**MAJOR PROJECT ASSESSMENT:  
7-9 Gibbons Street, Redfern  
(MP08\_0112 MOD3)**

Director-General's  
Environmental Assessment Report  
Section 75W of the  
*Environmental Planning and Assessment Act 1979*

November 2012

PLAN OF: STRATUM SUBDIVISION OF
LOT 1 IN DP1164832

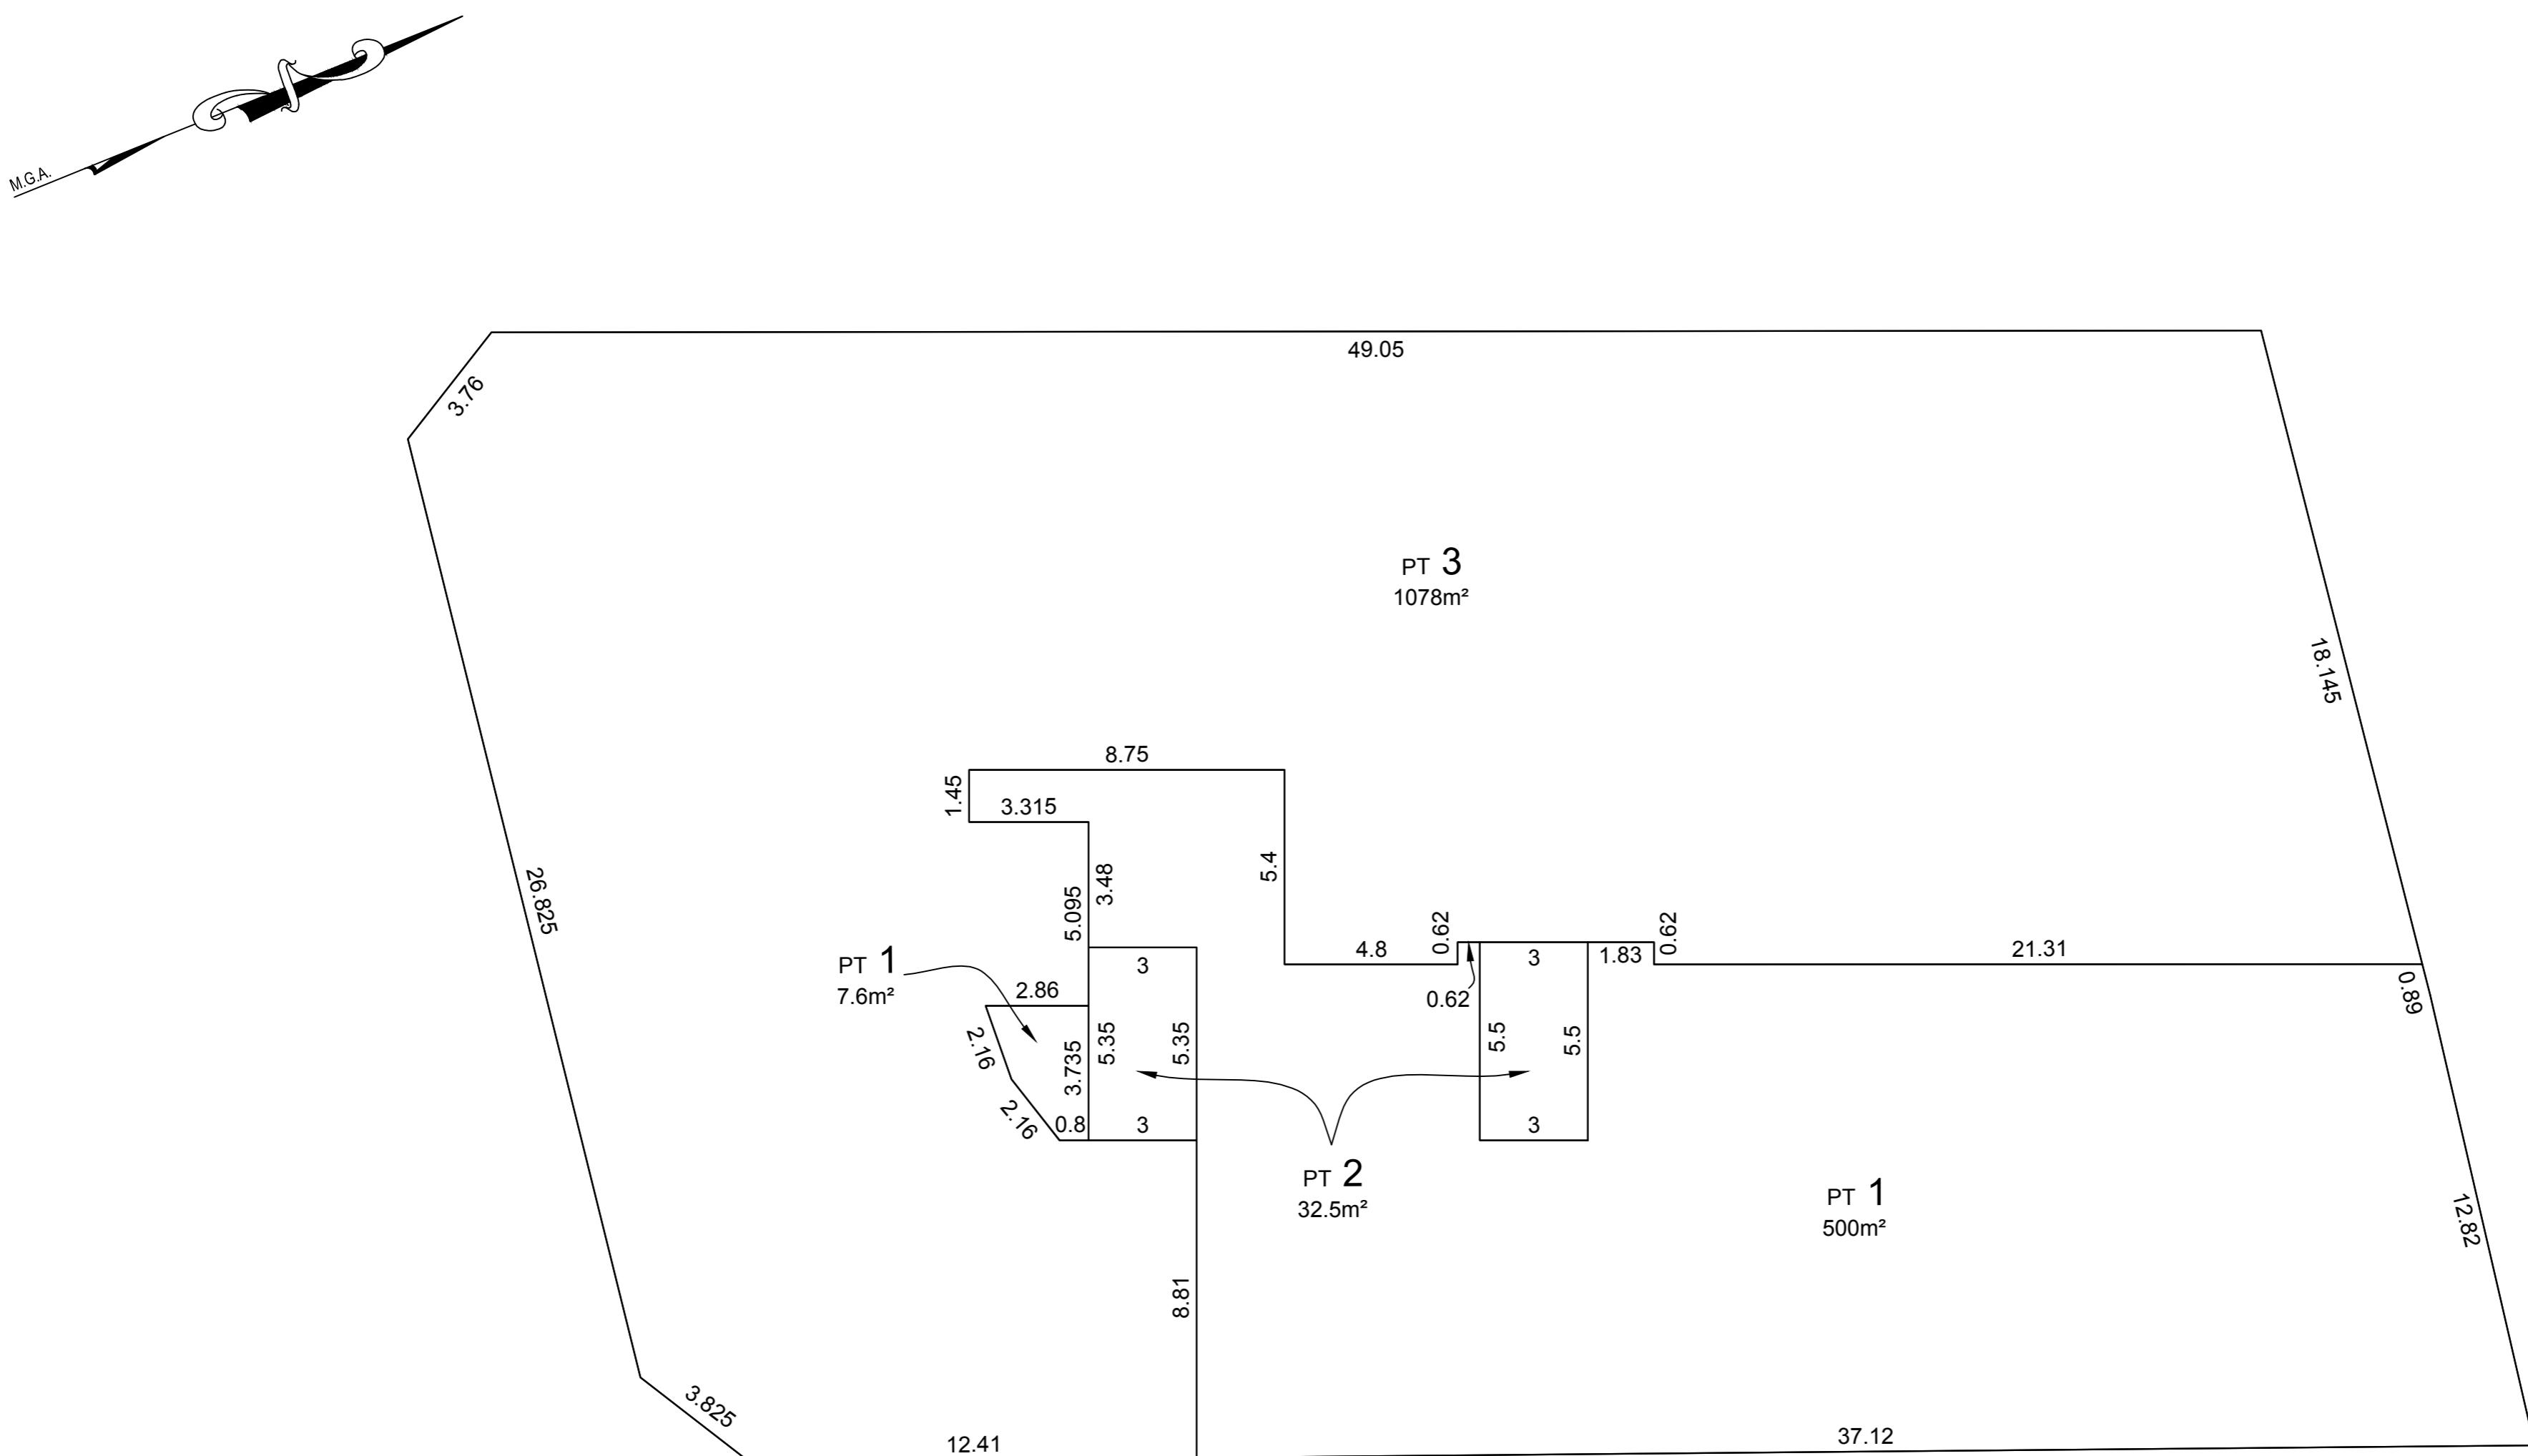
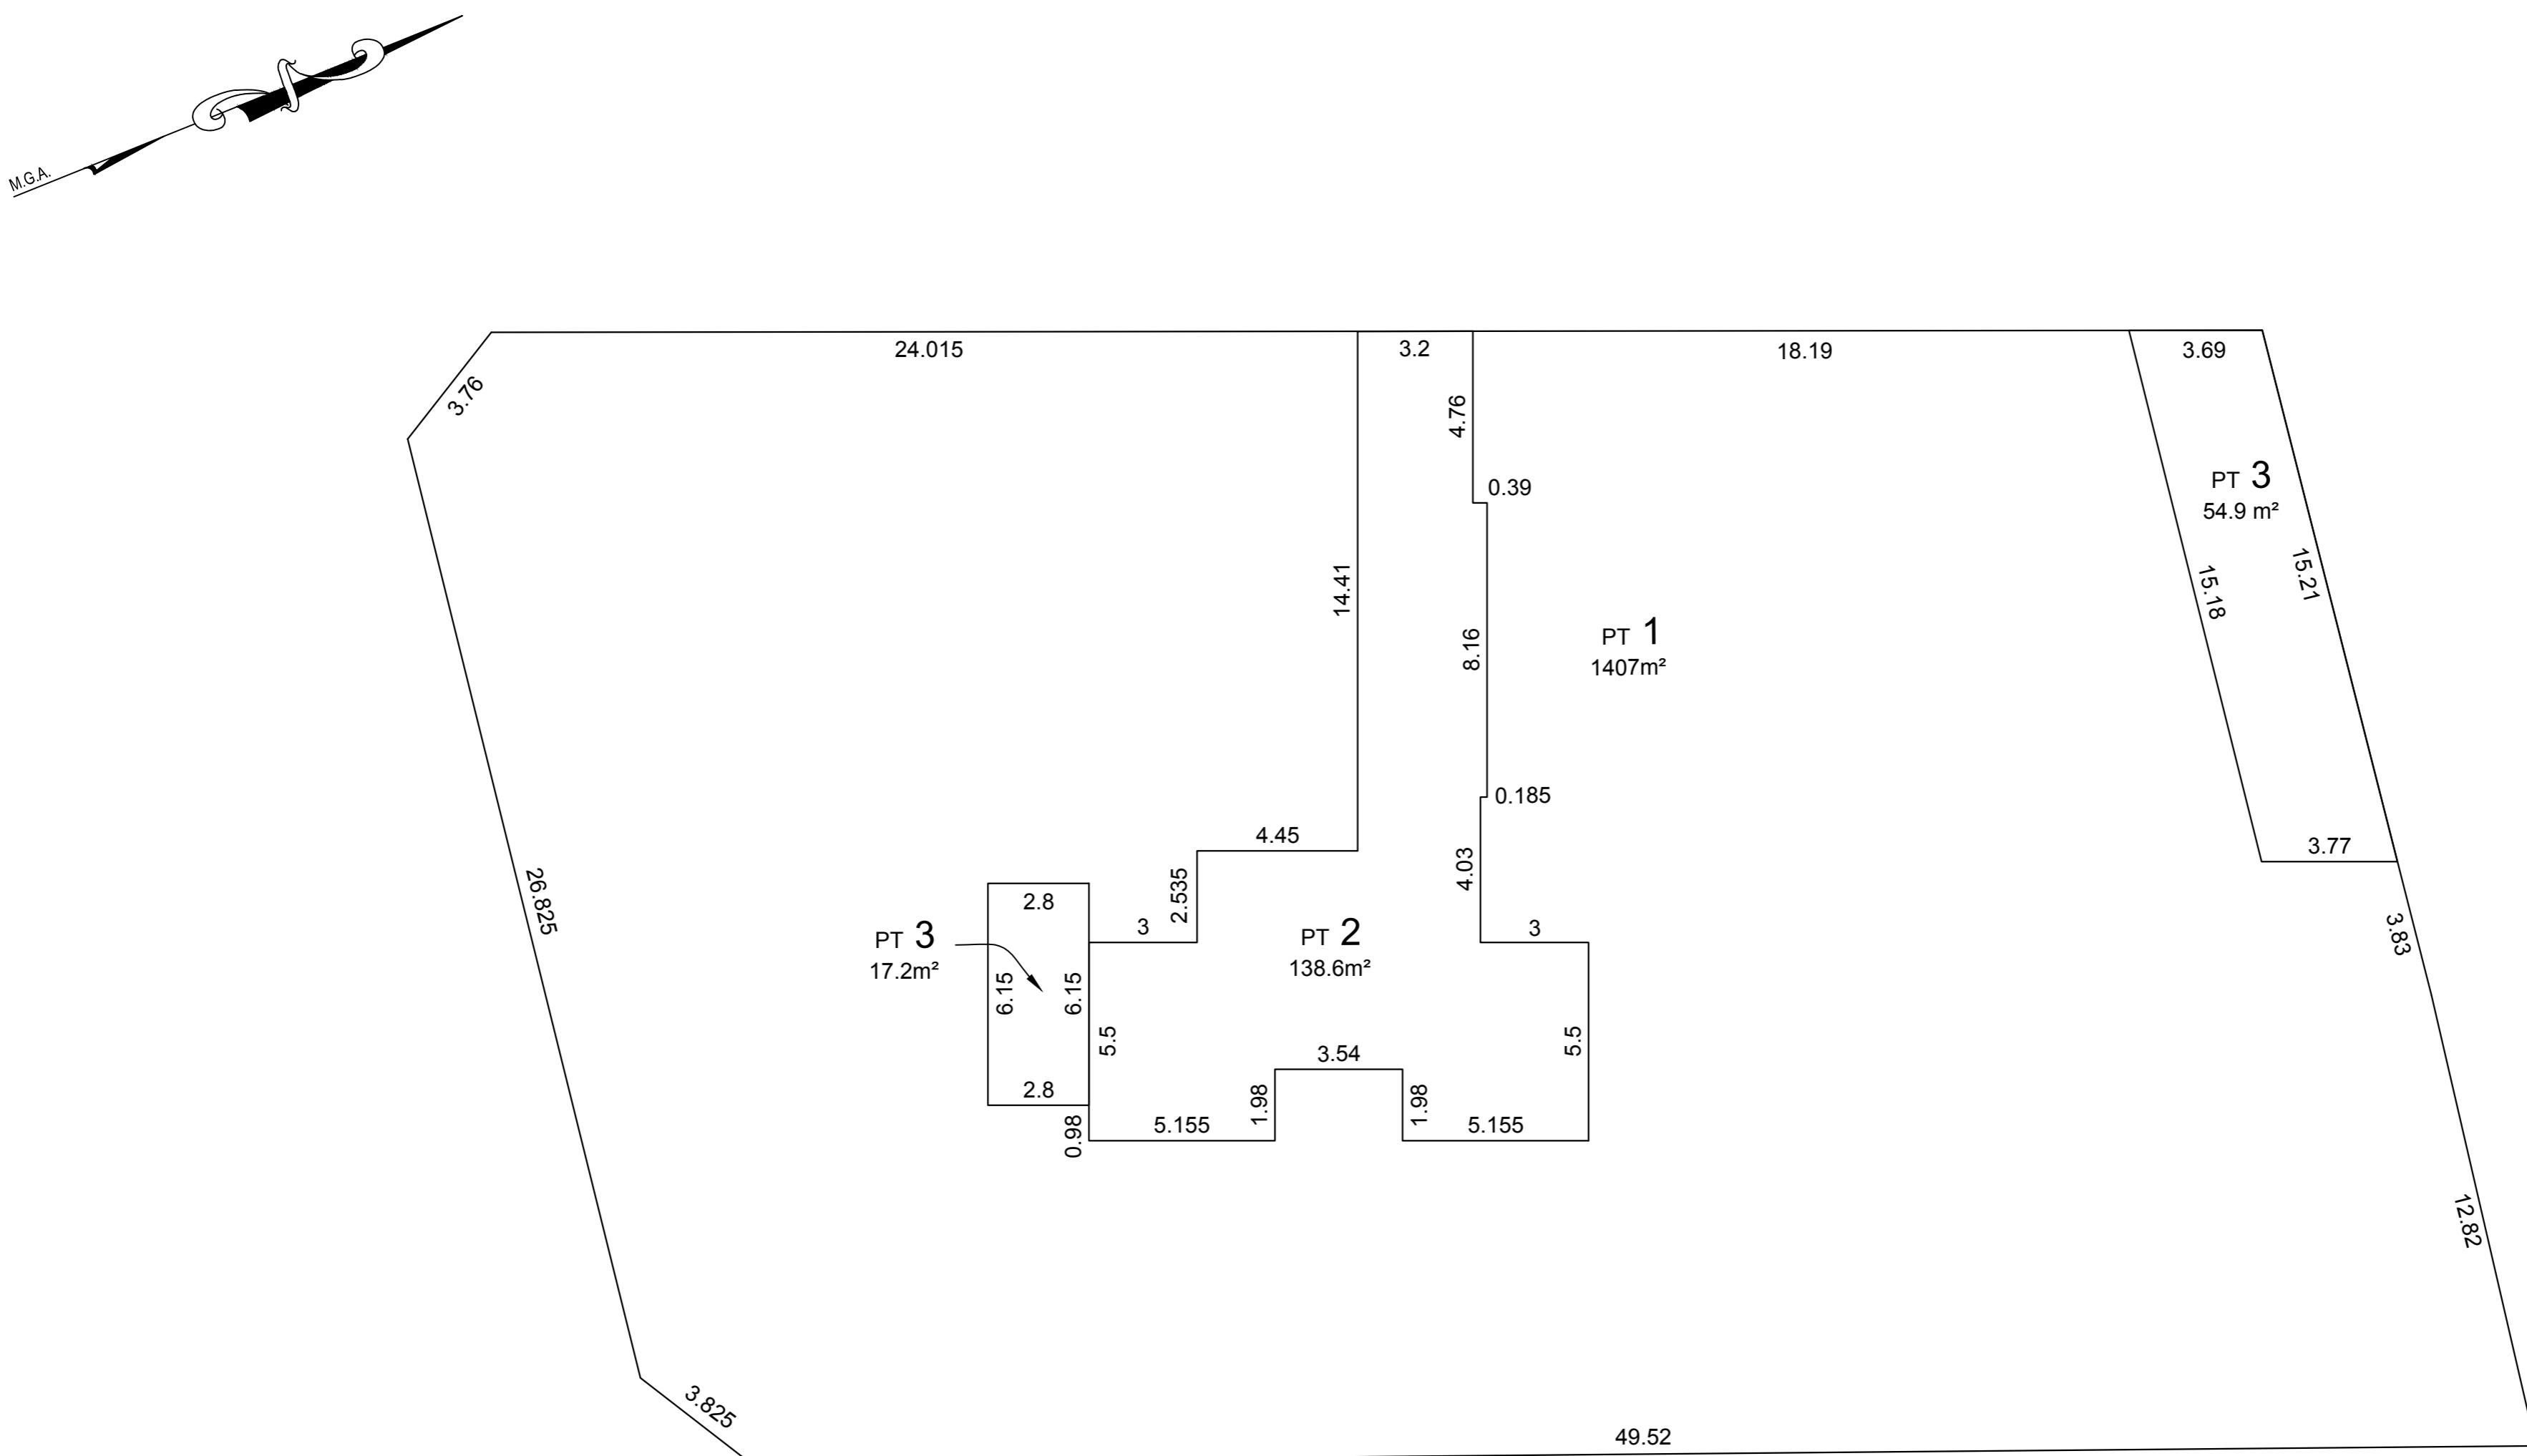
The modification request includes a draft stratum subdivision plan for the following allotments:

The Department considers the stratum subdivision to be consistent with the project approval and raises no issues in this regard. It is further noted that the draft stratum plan is generally consistent with the parking provision requirements contained in Condition A10 of the project approval. Although the specific number of car parking spaces allocated for each stratum lot have not been specifically nominated, the stratum subdivision does not preclude the requirement of the proposal to provide the car parking numbers listed in Condition A10. Therefore, the Department maintains confidence that the required number of car parking spaces will be provided.
